The following concerns have been raised by Harborview Flats residents, abutters to the 133 York St Condo proposal

Concerns regarding long-term viability of green wall for privacy screening

## Passenger Car at 5 mph, Space 1

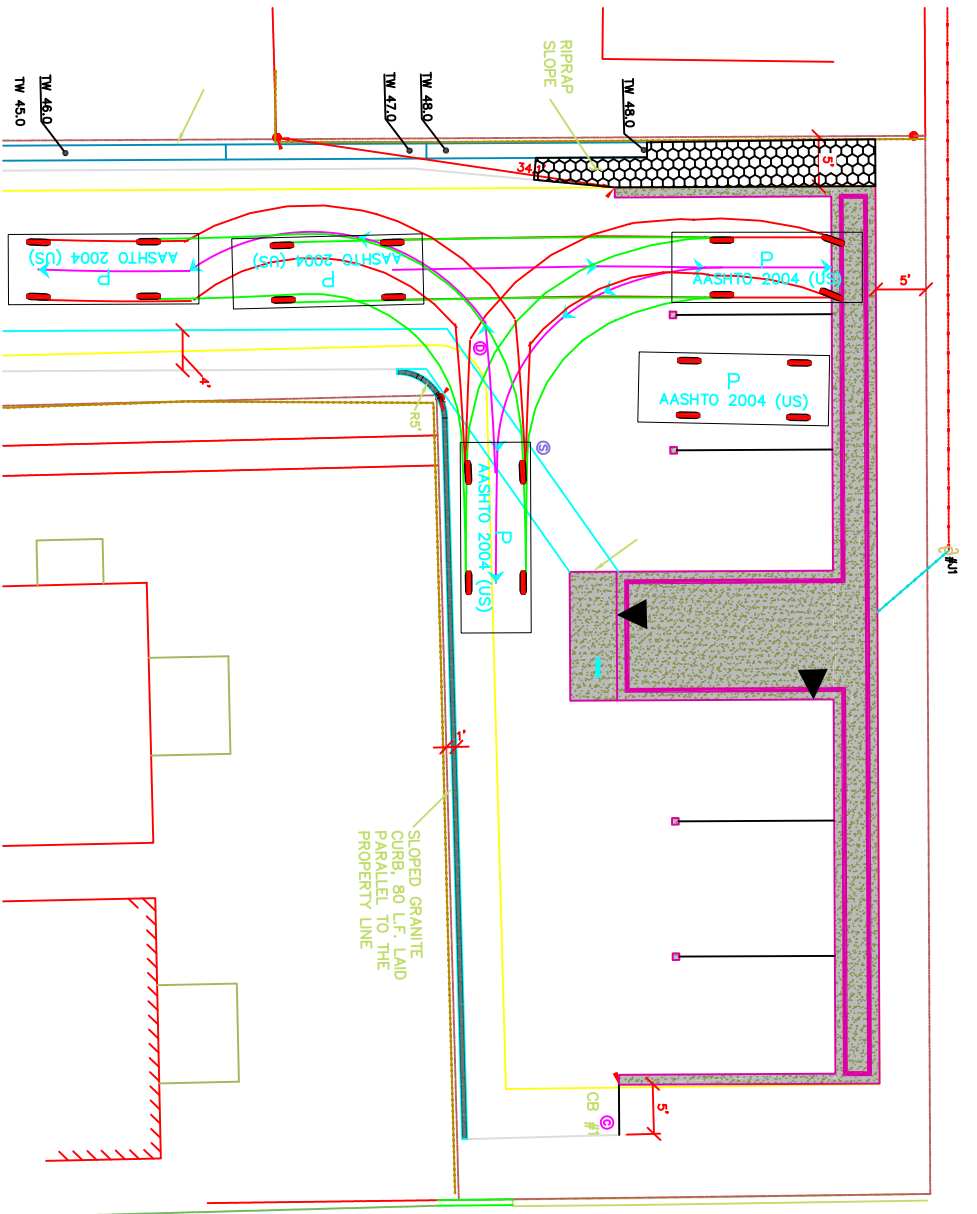
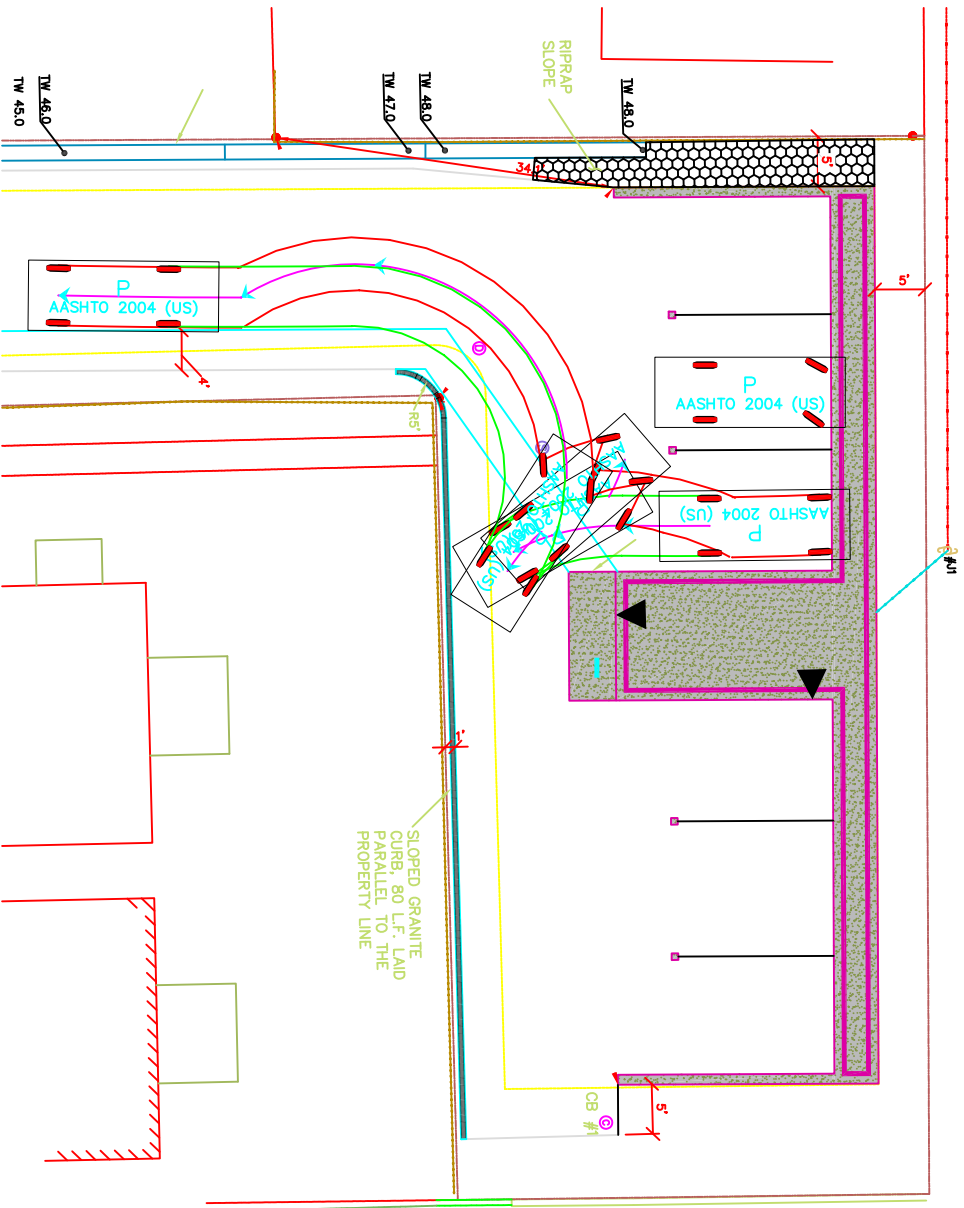
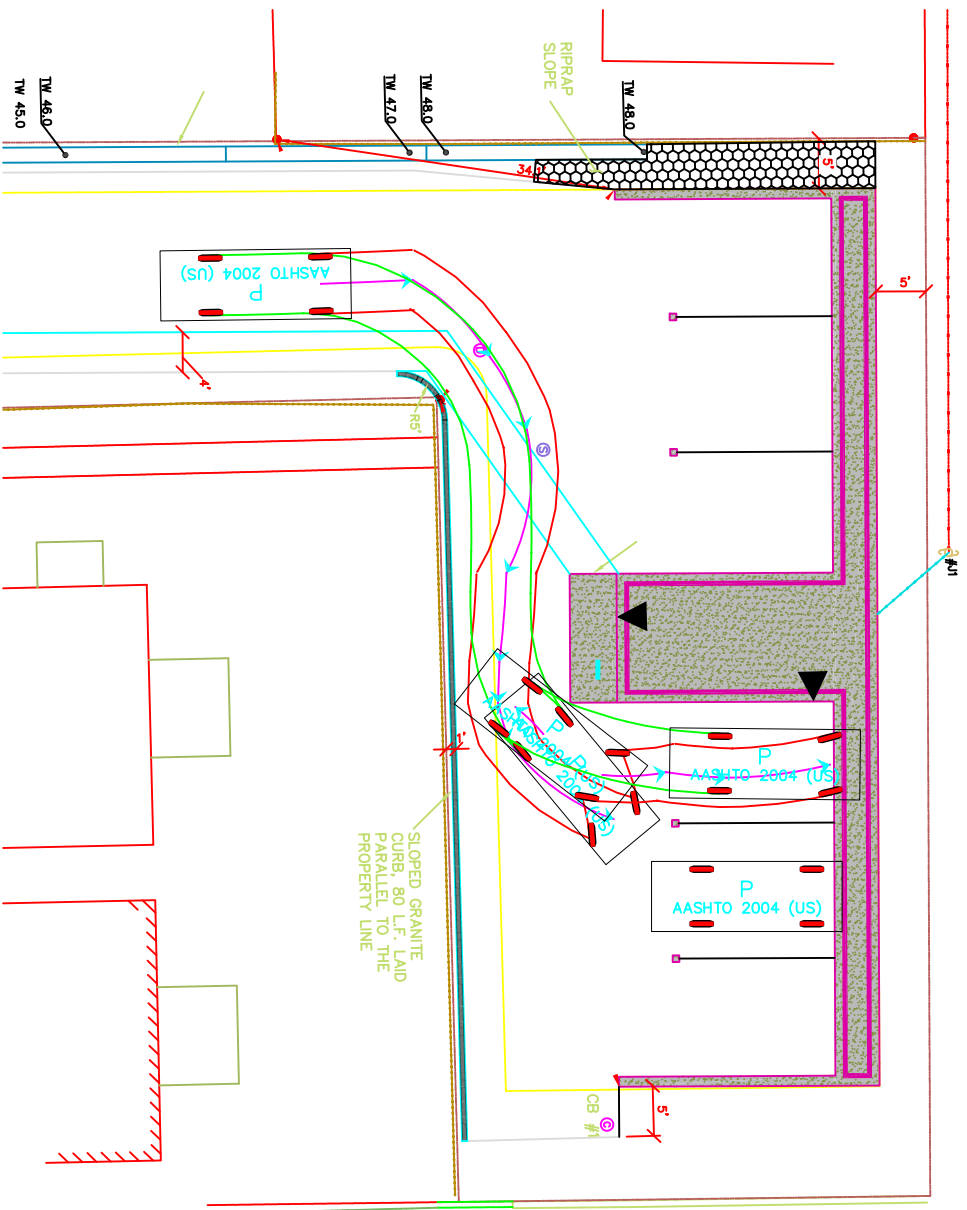
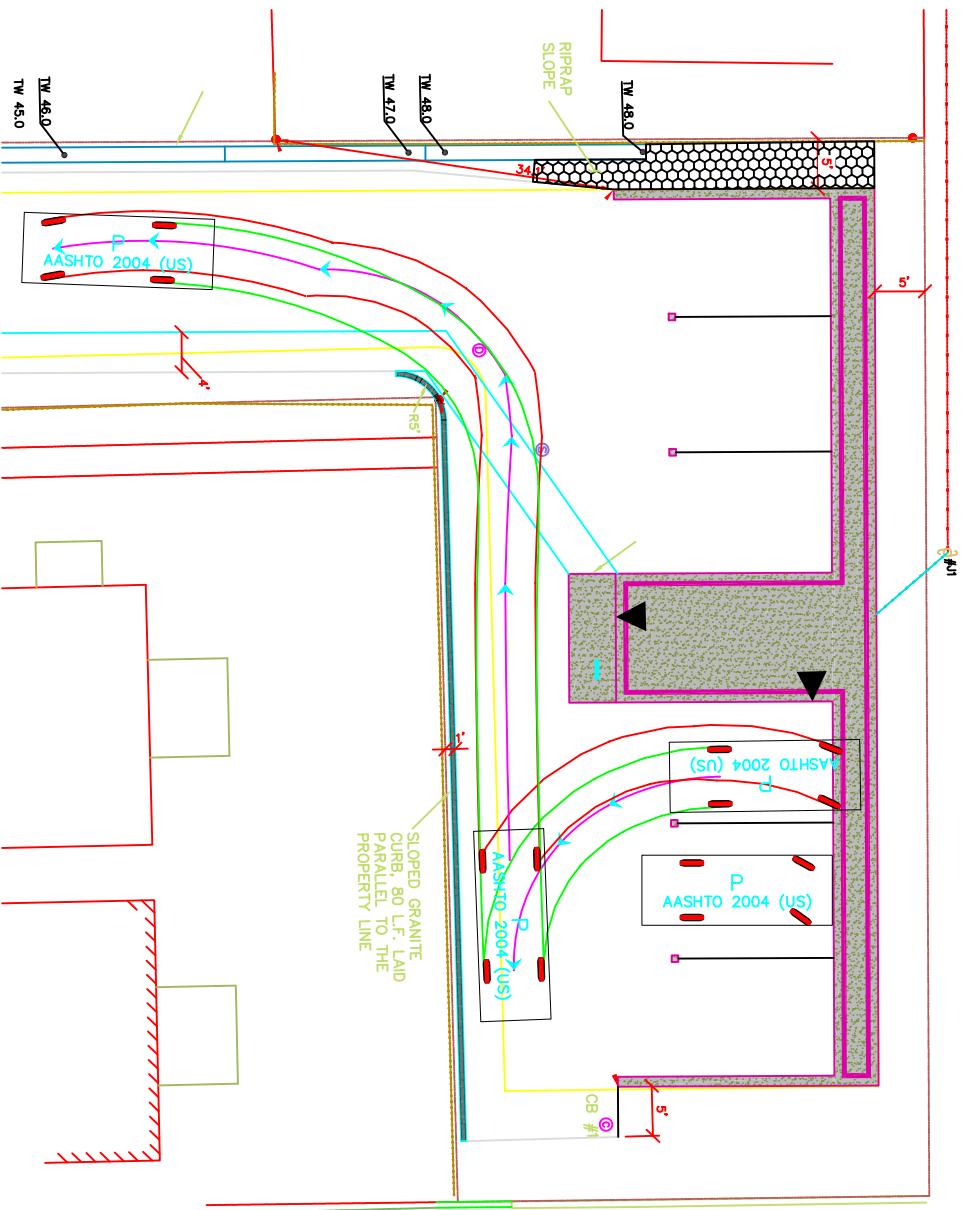
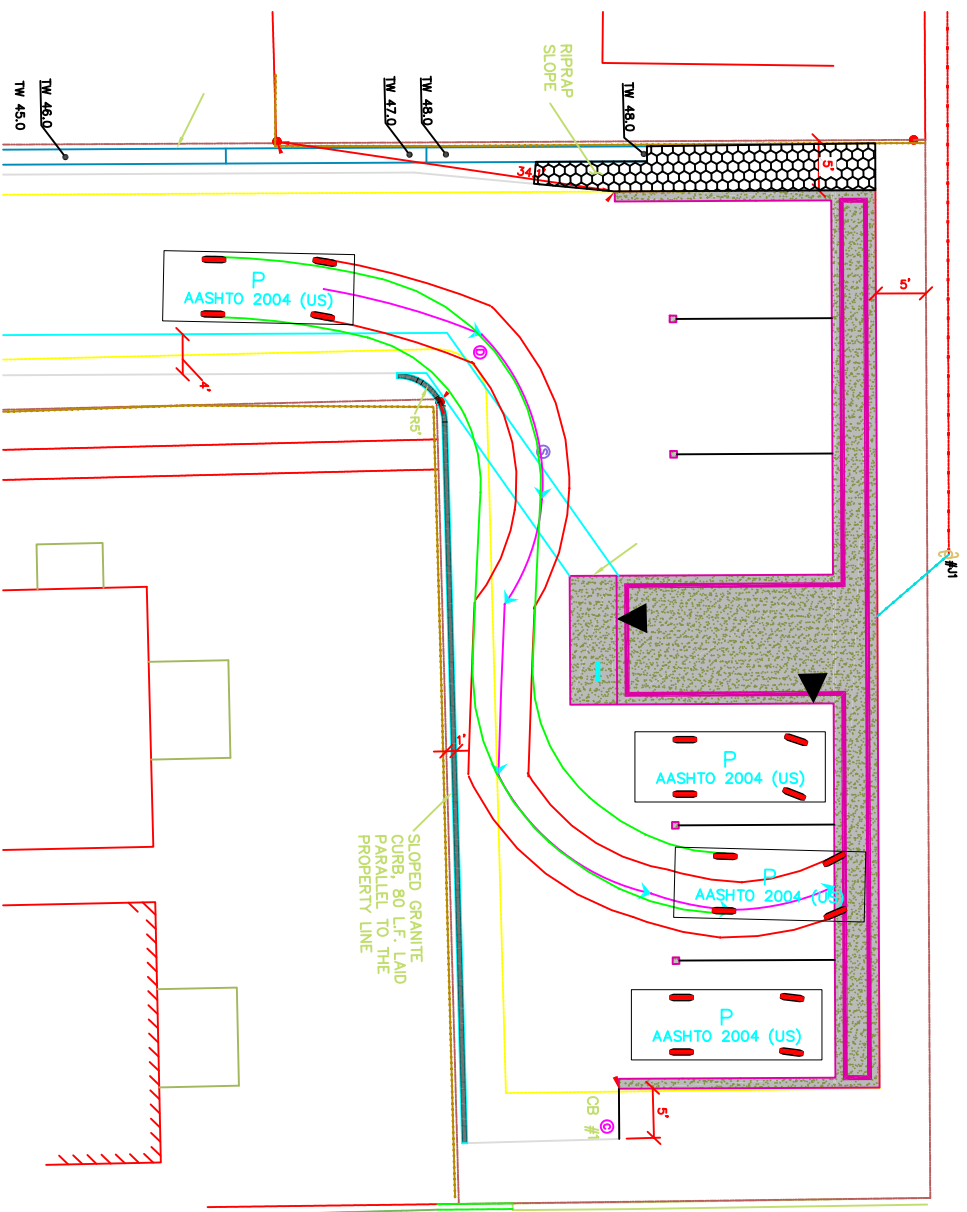
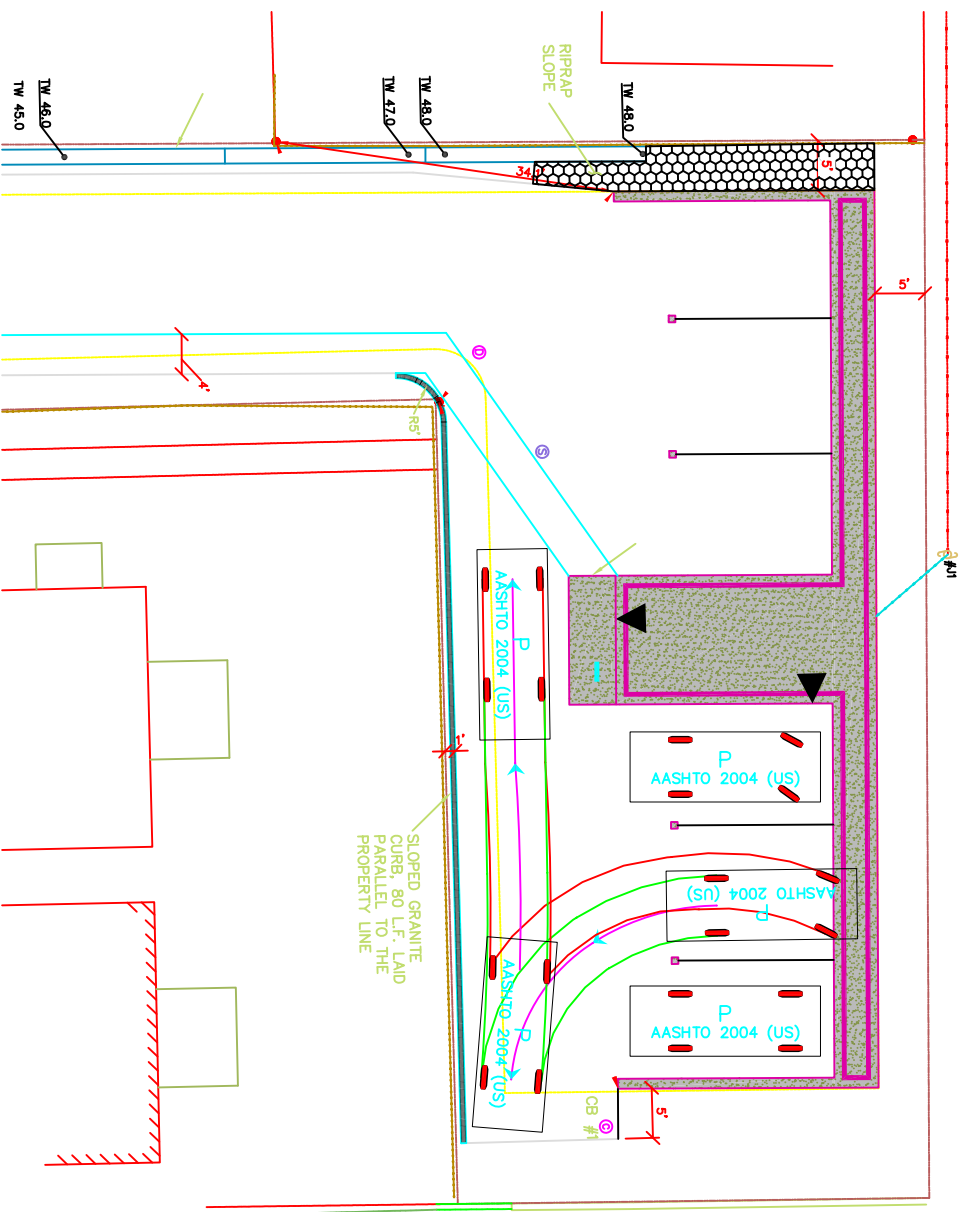
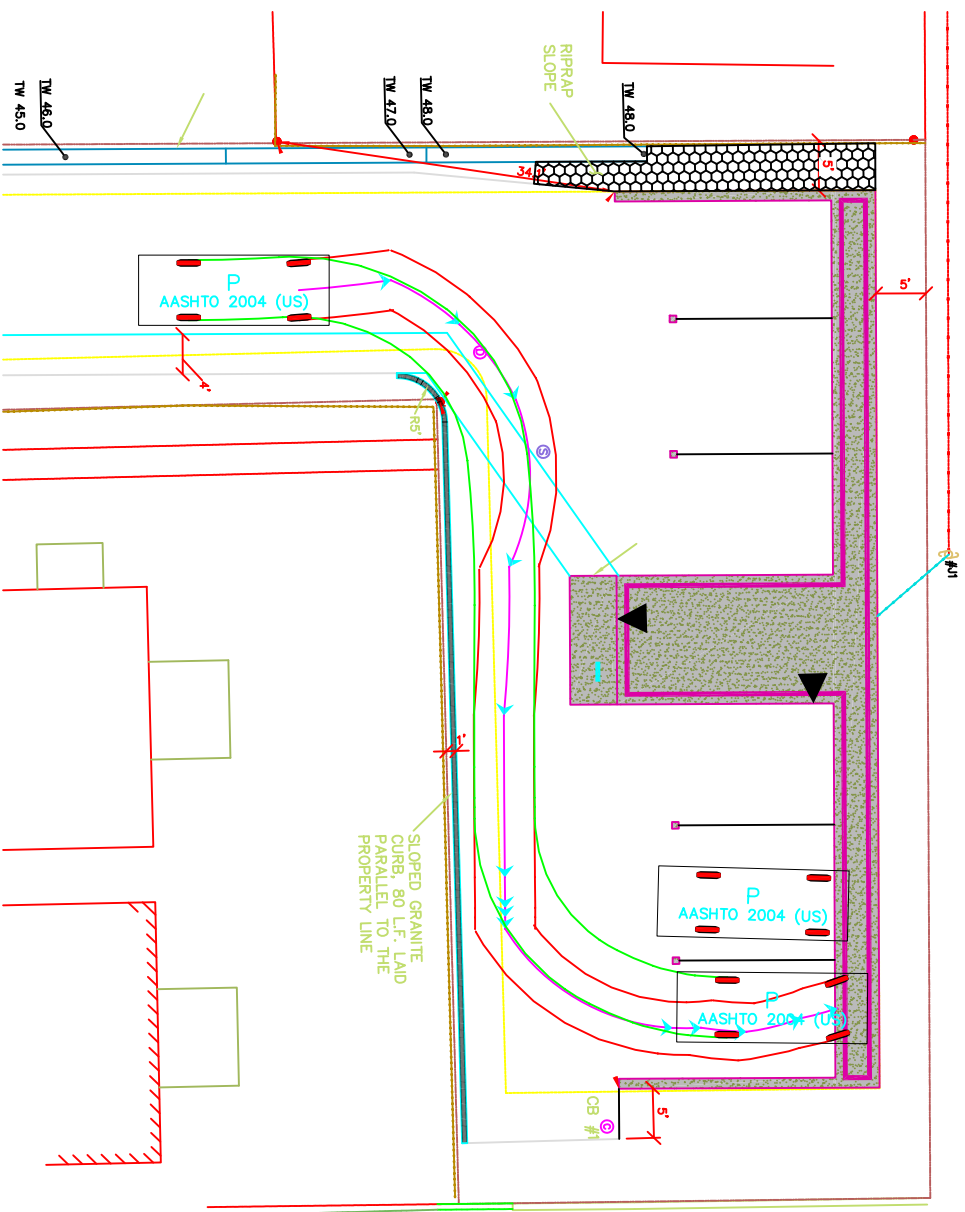
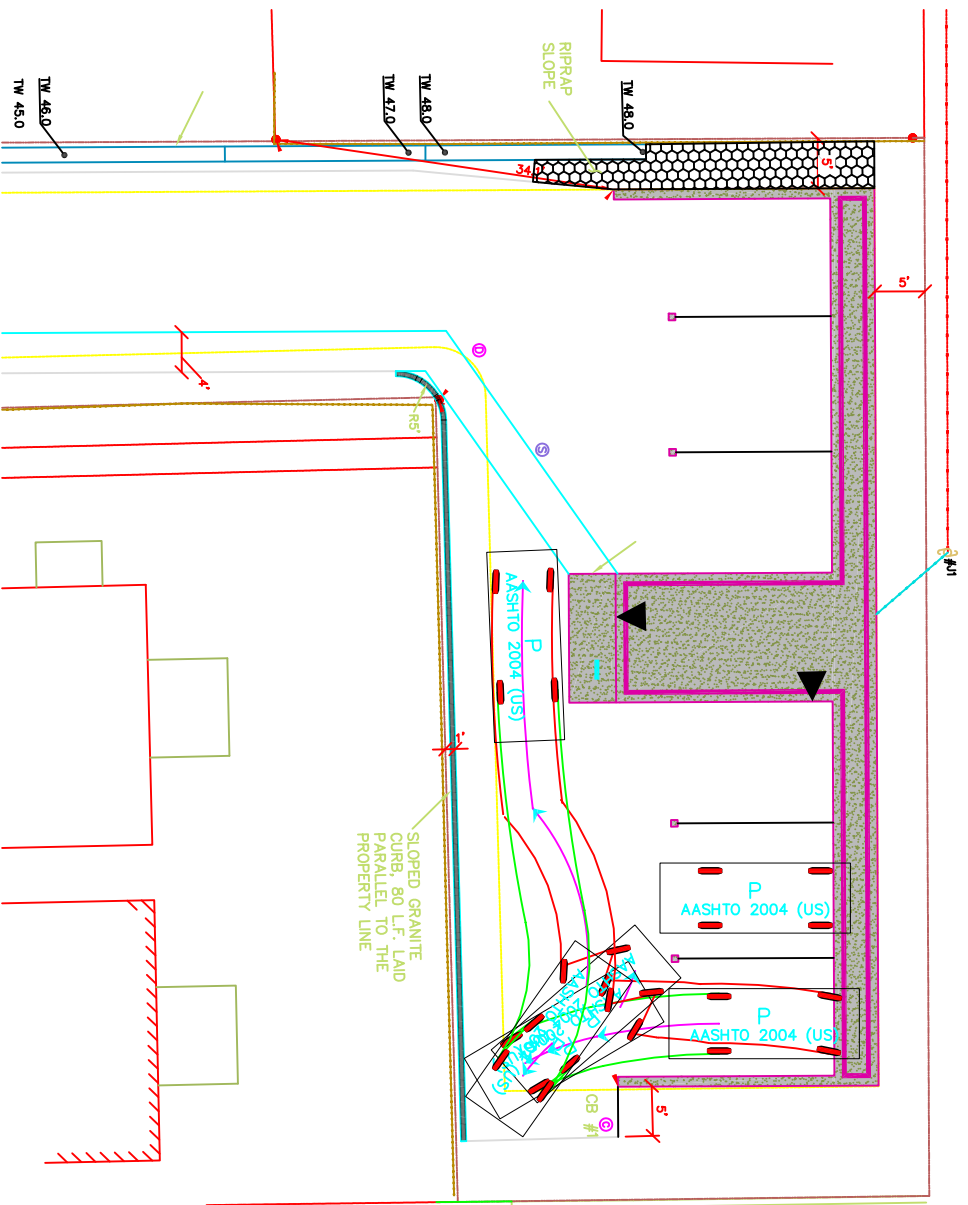
1. Cars exceeding the dimensions and/or turning circle of the car in Pinkham and Greer's parking diagrams (Consumer Reports 2013 auto data lists 17 passenger vehicles that exceed the dimensions and/or turning circle of the car in the Pinkham and Greer's report). See parking diagrams below.
2. More than one car trying to enter/exit the rear parking at a time
3. Delivery trucks such as a UPS (UPS trucks are 6' longer than the example car)
4. Trucking snow off property
5. Waste disposal

Note: Pinkham and Greer's car parking diagrams (shown below) have dimensions for the car but the report does not show the dimensions the driveway areas.
